ASSESSMENT REPORT

ORICA SOUTHLANDS PROJECT – BOTANY INDUSTRIAL ESTATE MP 06_0191 MOD 3

(a) As-Con with Turning Head at RL~3.85m (Scenario 1) Flow Depth

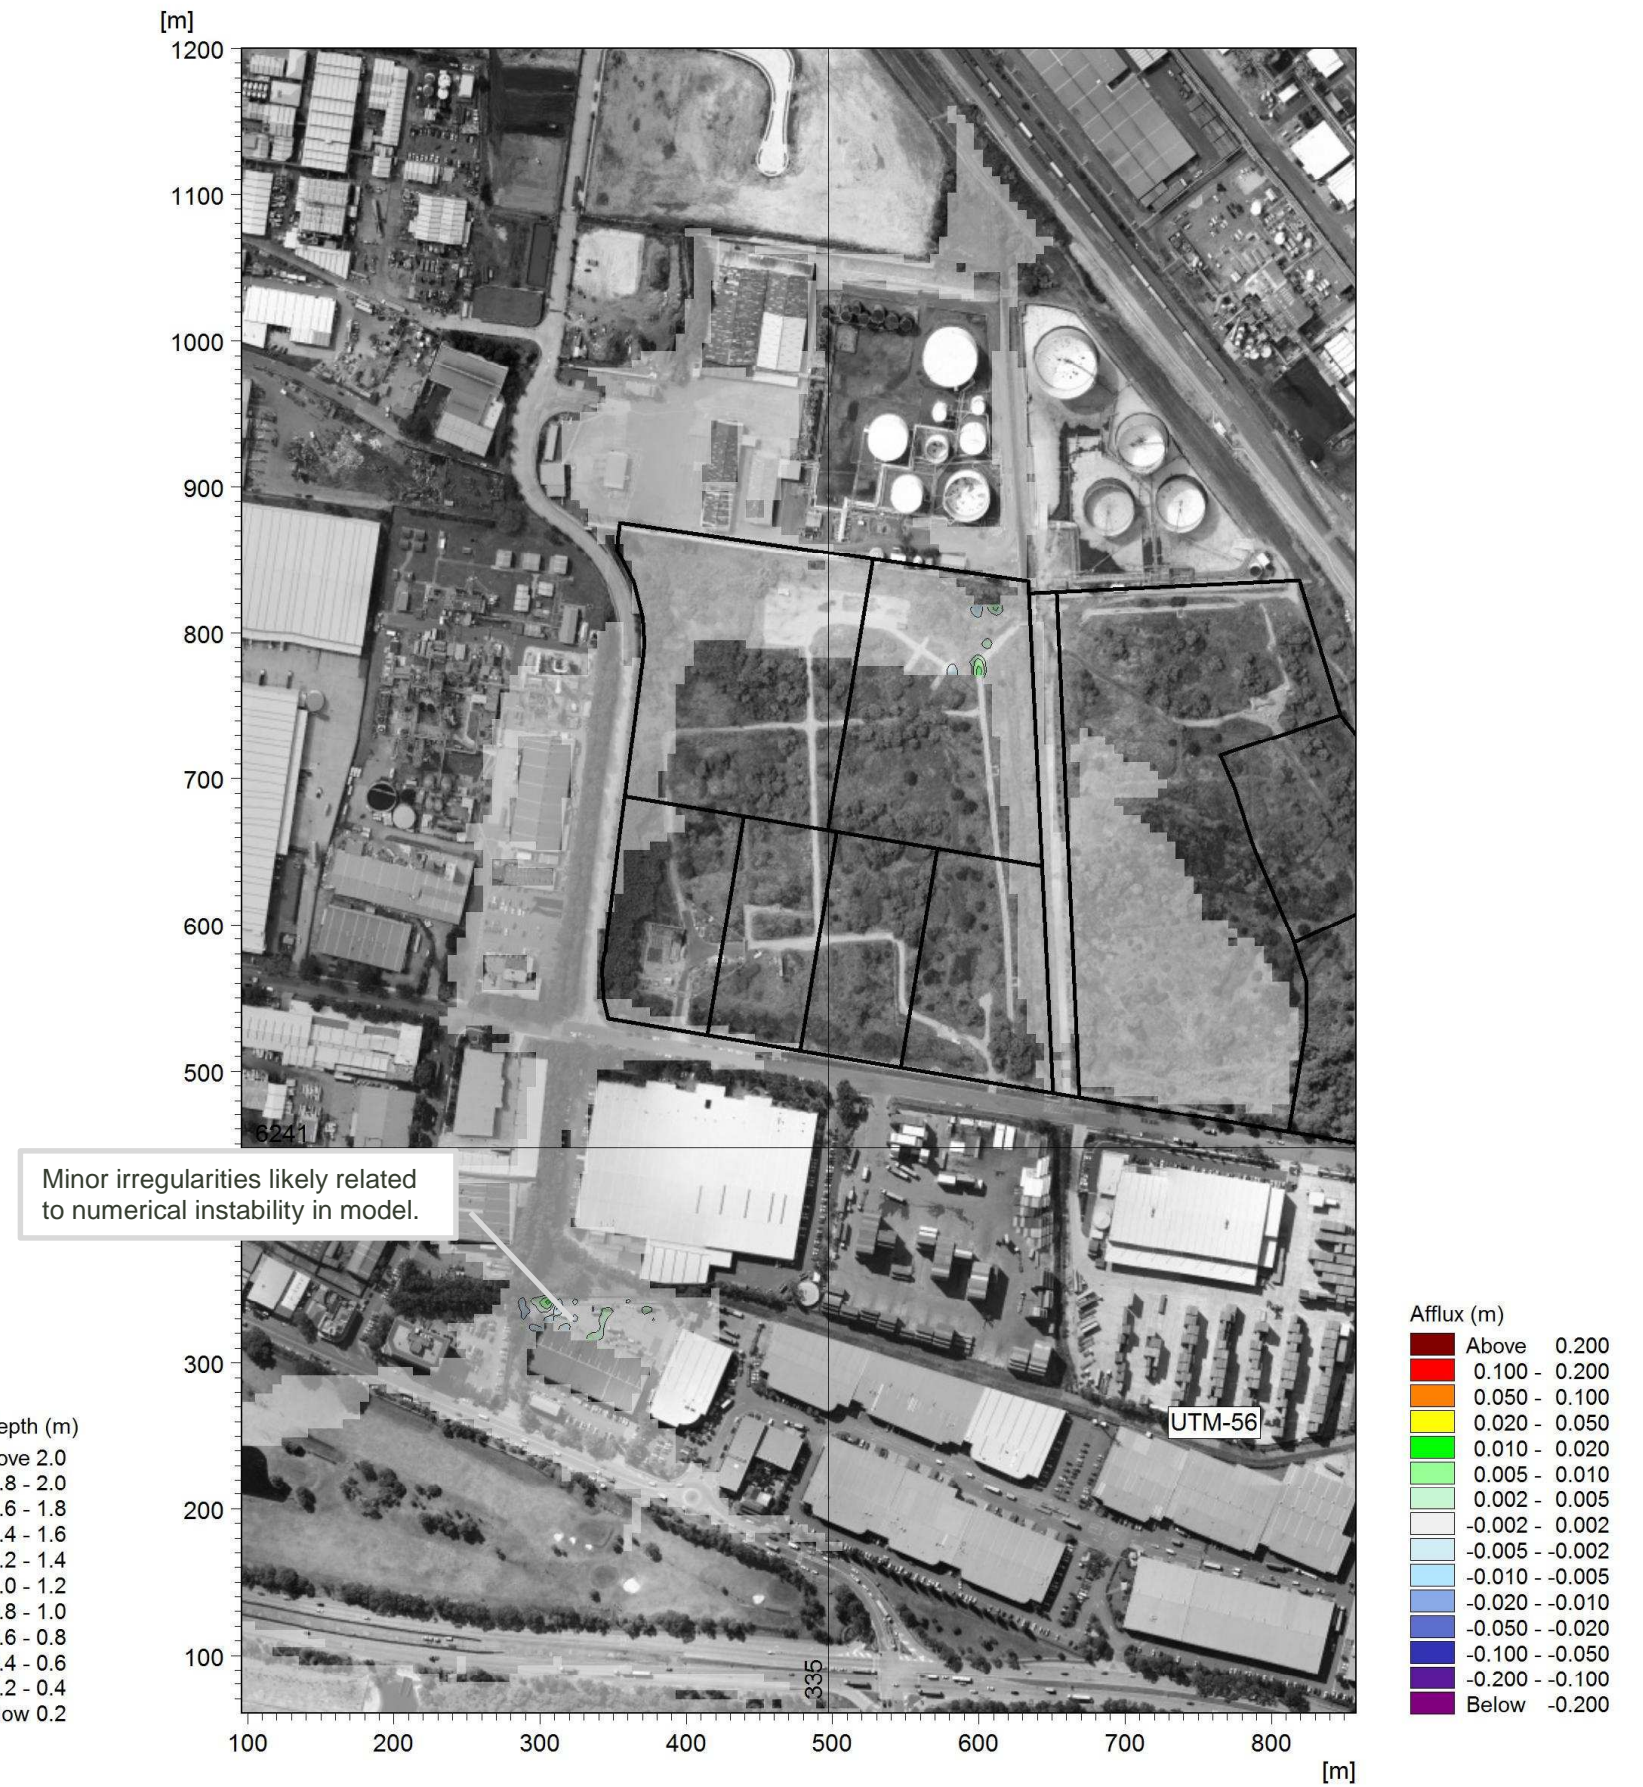
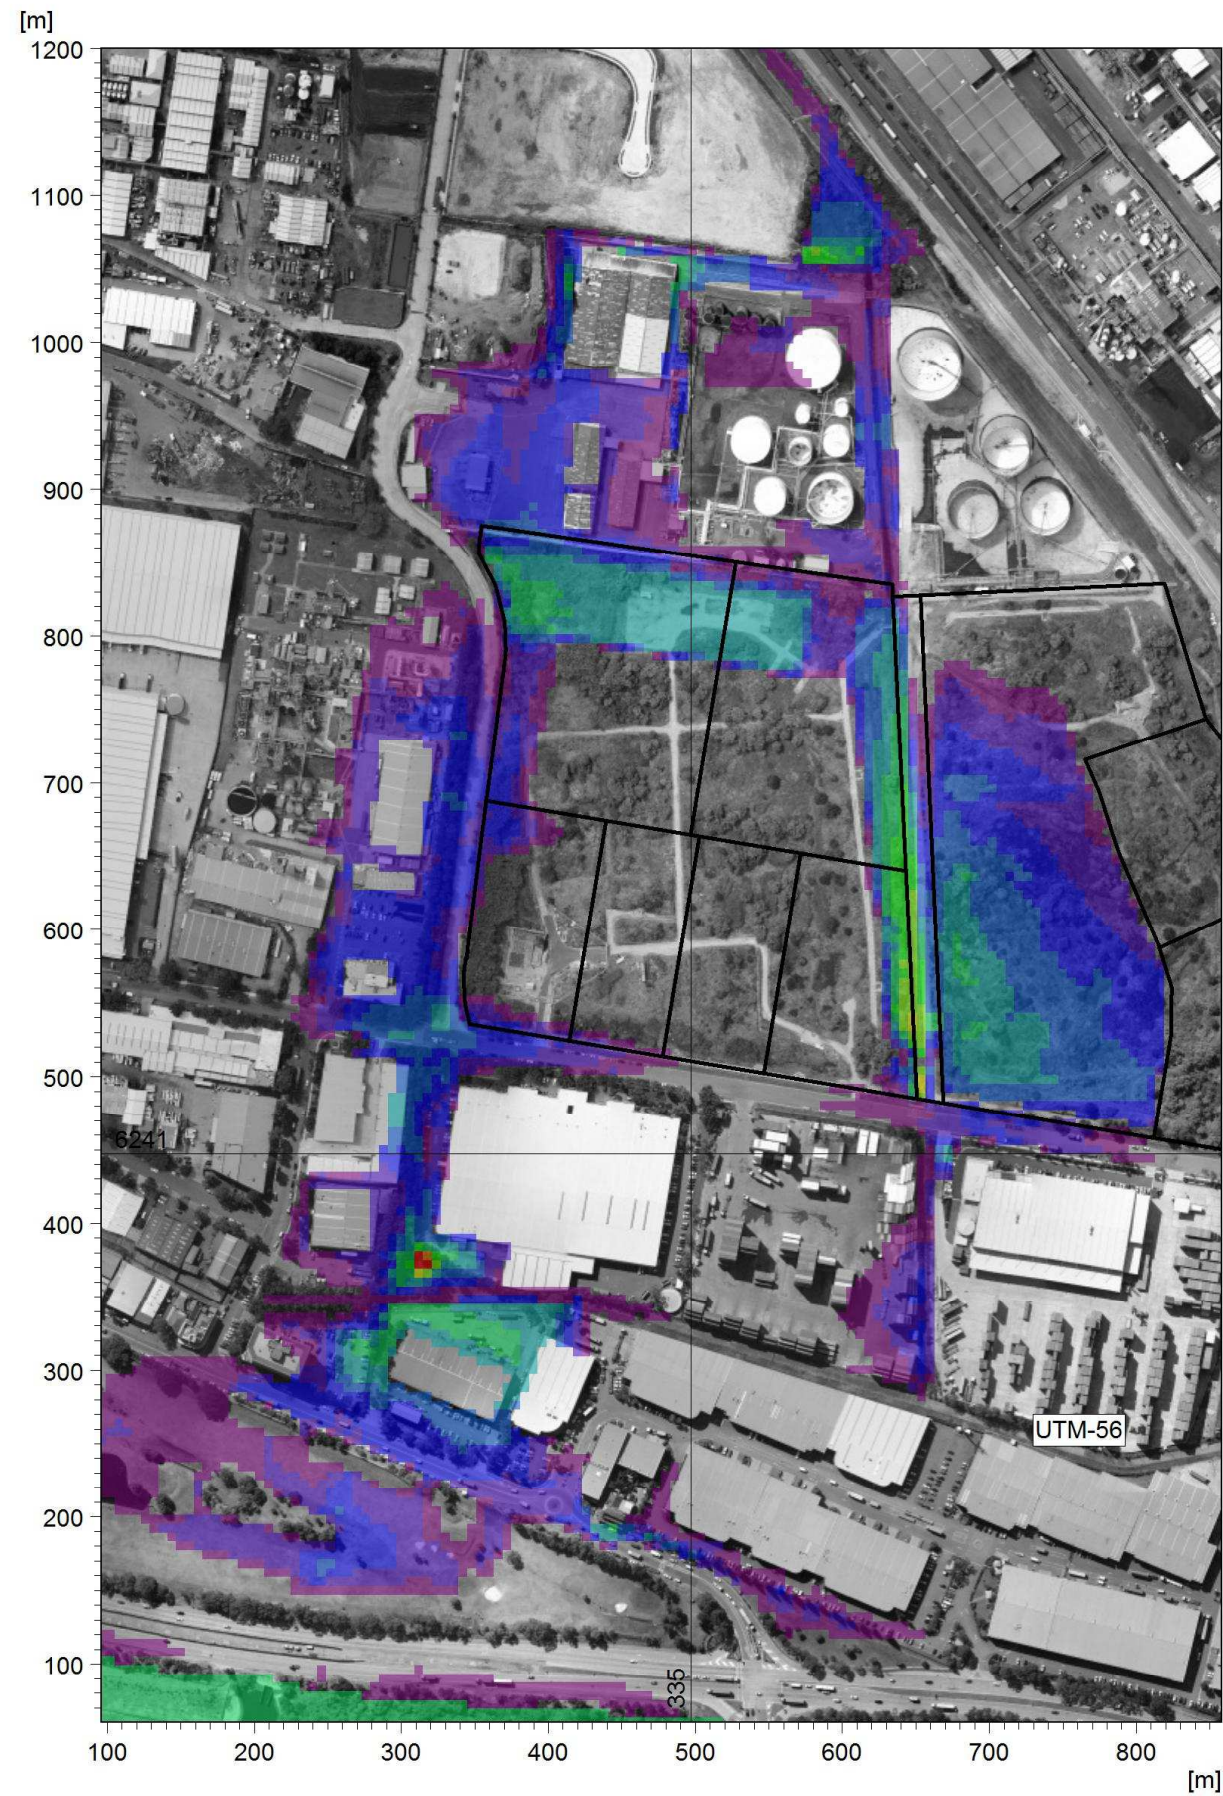
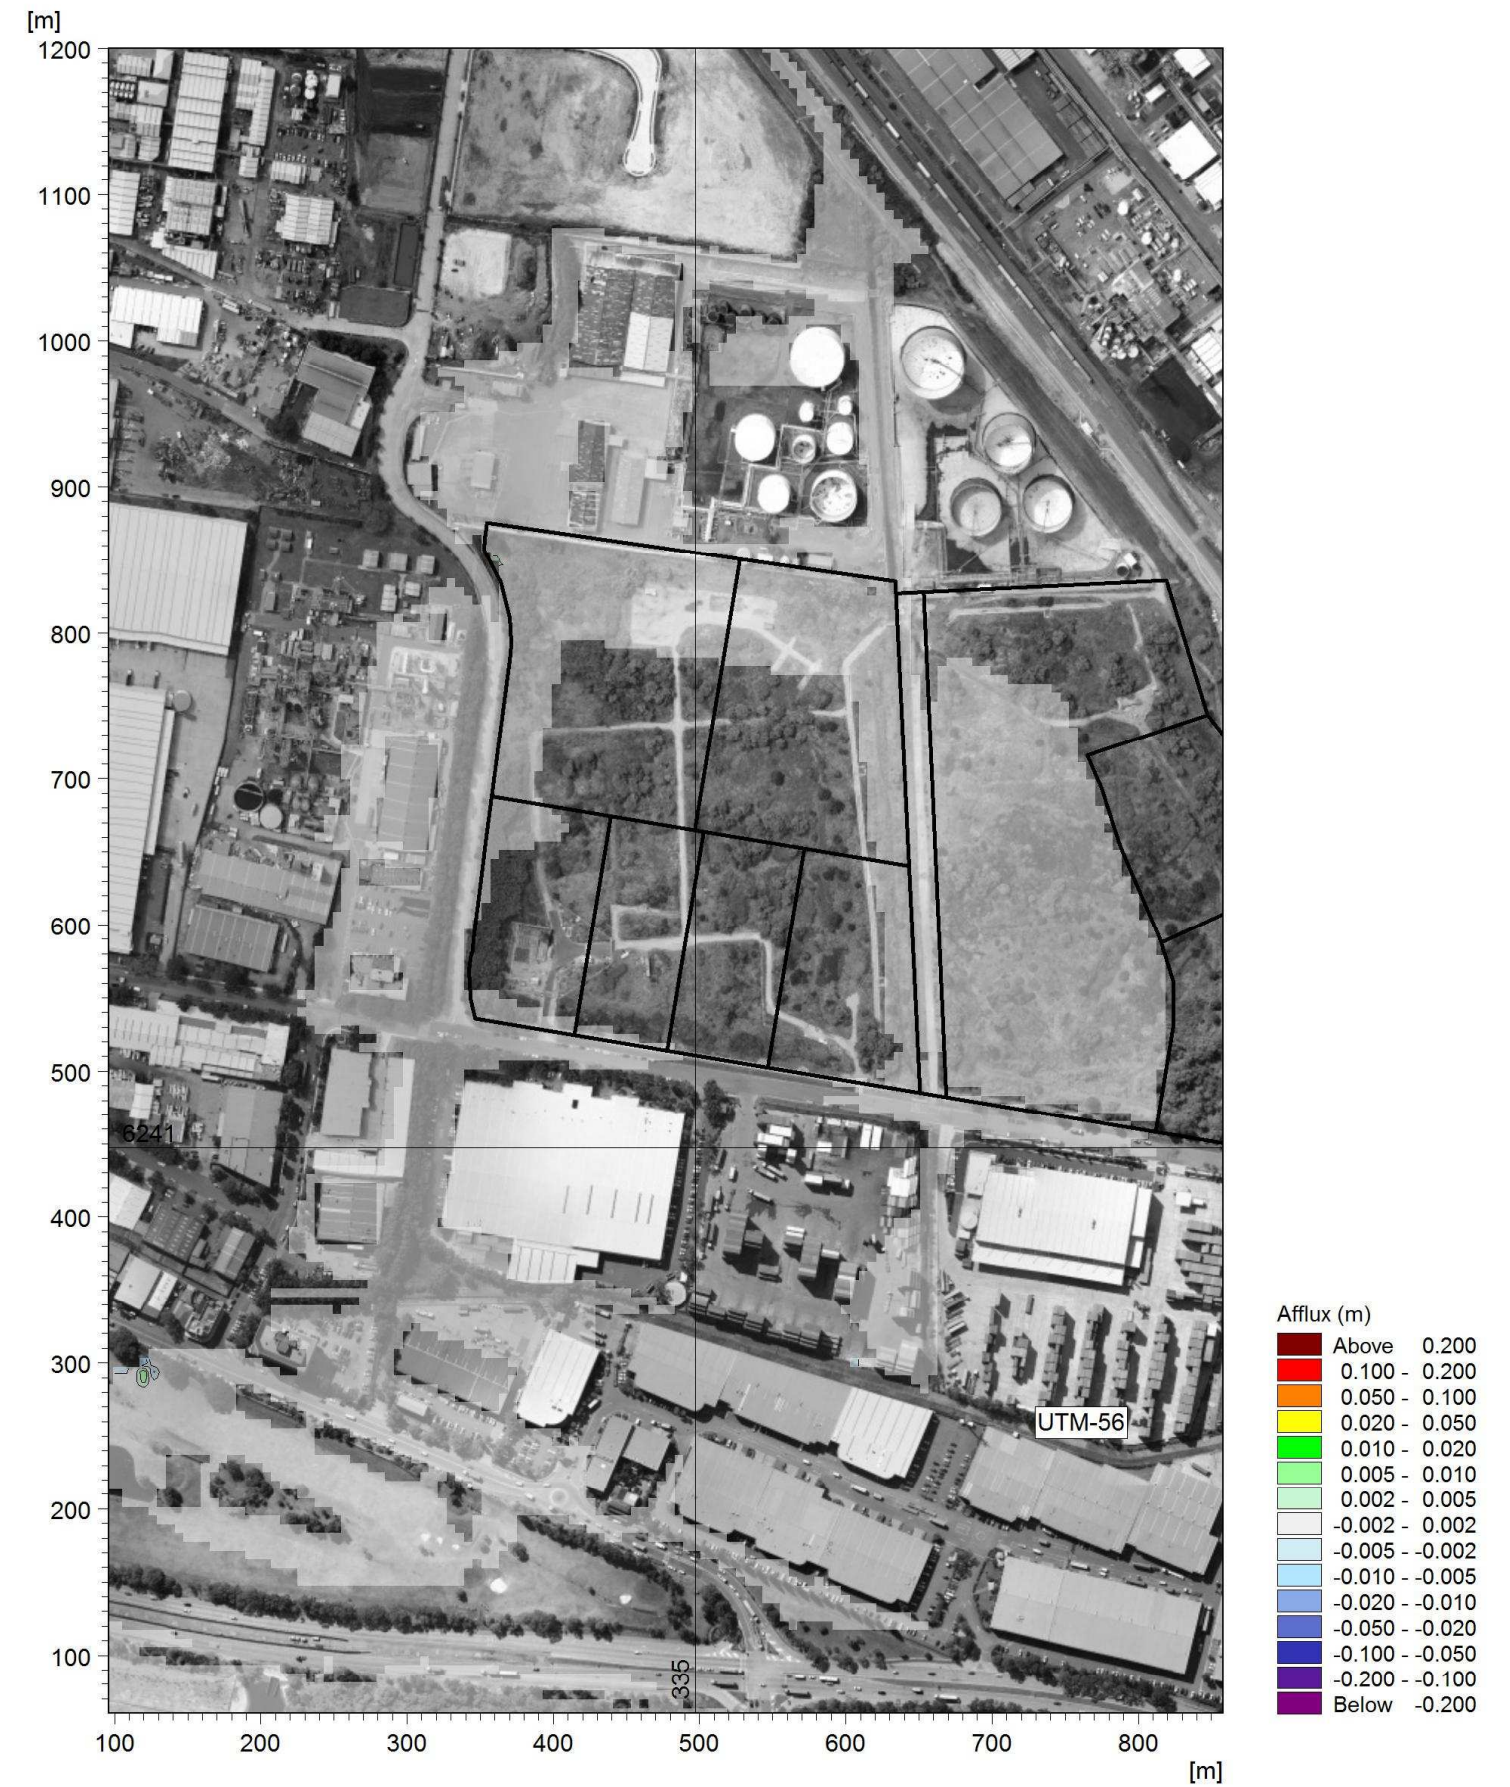
Following the submission of the Response to Submissions (RTS), Council advised it had one remaining concern, regarding the proposed height of the turning circle, noting that it is currently proposed at a level of RL 3.8 metres which is below the 1:100 year flood level. Council requested a condition be inserted to raise the level to RL 4.0 metres.

Council also raised concern with the level of the turning circle which varies between RL 3.8 metres and RL 4.6 metres. Council were concerned that the turning circle would not provide flood free access for emergency vehicles if it is constructed below RL 4.0 metres and requested a condition be incorporated which requires the finished level of the turning circle to be above RL 4.0 metres.

The peer review endorsed the proposed height of the turning circle for emergency vehicle access noting that:

- raising the level would result in additional and unacceptable increases in the flood level;
- the turning circle is proposed to service fire and rescue vehicles, and the likelihood of a coincident flood and fire event occurring is very rare; and
- flood depth warning signs would be provided so drivers can make an informed decision about whether to use the turning circle.

The Department is also of the view that the height of the turning circle is acceptable for emergency vehicle access at a height of RL 3.80 metres on the basis that:

- an increase in height would potentially cause unacceptable flood level increases;
- the probability of a fire at the time of a 1:100 year flood event is rare;
- flood depth warning signs would be provided, allowing fire services to make an informed decision regarding the use of the turning circle during a flood event; and
- emergency vehicles would still have access to the site during a flood event as fire trucks

are designed to traverse low level flood waters, and there is sufficient space in the car park to execute a three point turn without the need of the turning circle.
